City of Albuquerque

UTILITY DEVELOPMENT DIVISION
HYDROLOGY SECTION
(505) 768-2650

January 28, 1987

RE: DRAINAGE PLAN FOR MEDICAL OFFICES ON LEAD & LOCUST
(K-15/D41) RECEIVED DECEMBER 16, 1986

**DRAINAGE/GRADING PLAN**  
**MEDICAL OFFICES**  
**LEAD & LOCUST S.E.**

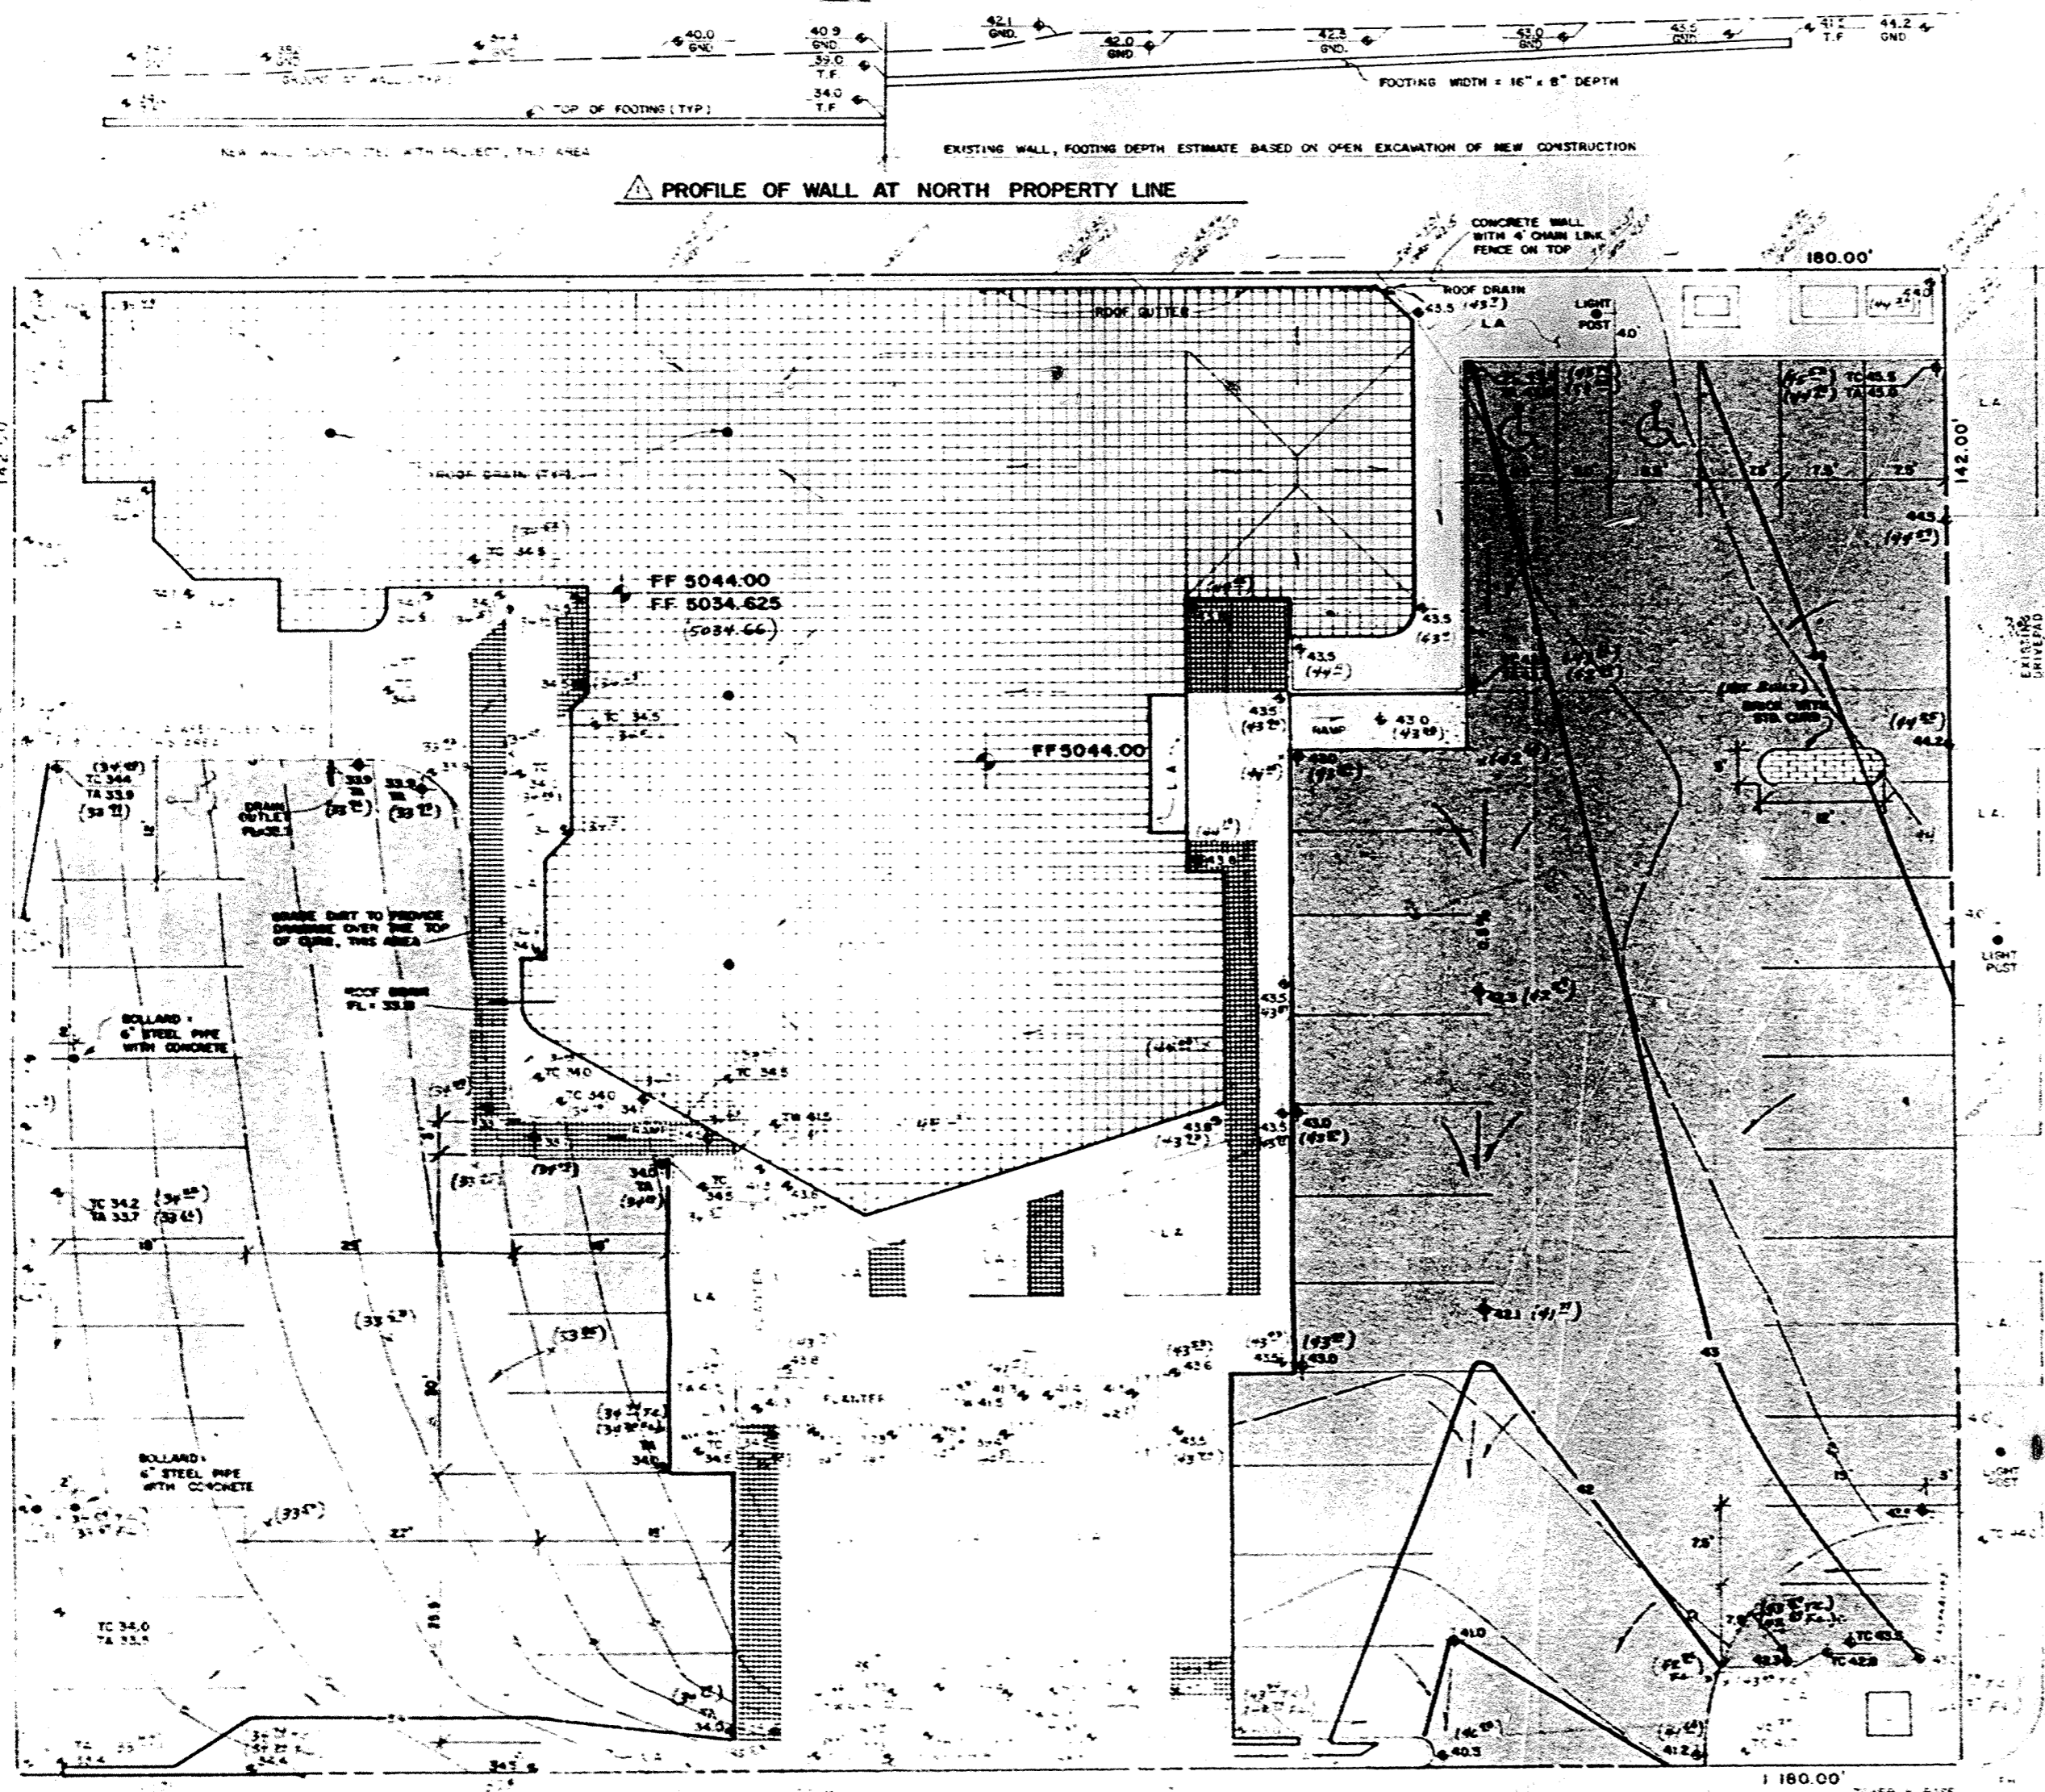
1. Replat, easements, or covenants required for drainage across lot lines before Building Permit is released.
2. Approved alley grades prior to Certificate of Occupancy. Proposed concrete wall on north property line must have sufficient footing depth for in case future improvements take place within the alley. Please provide conceptual alley grades and footing grades for review.
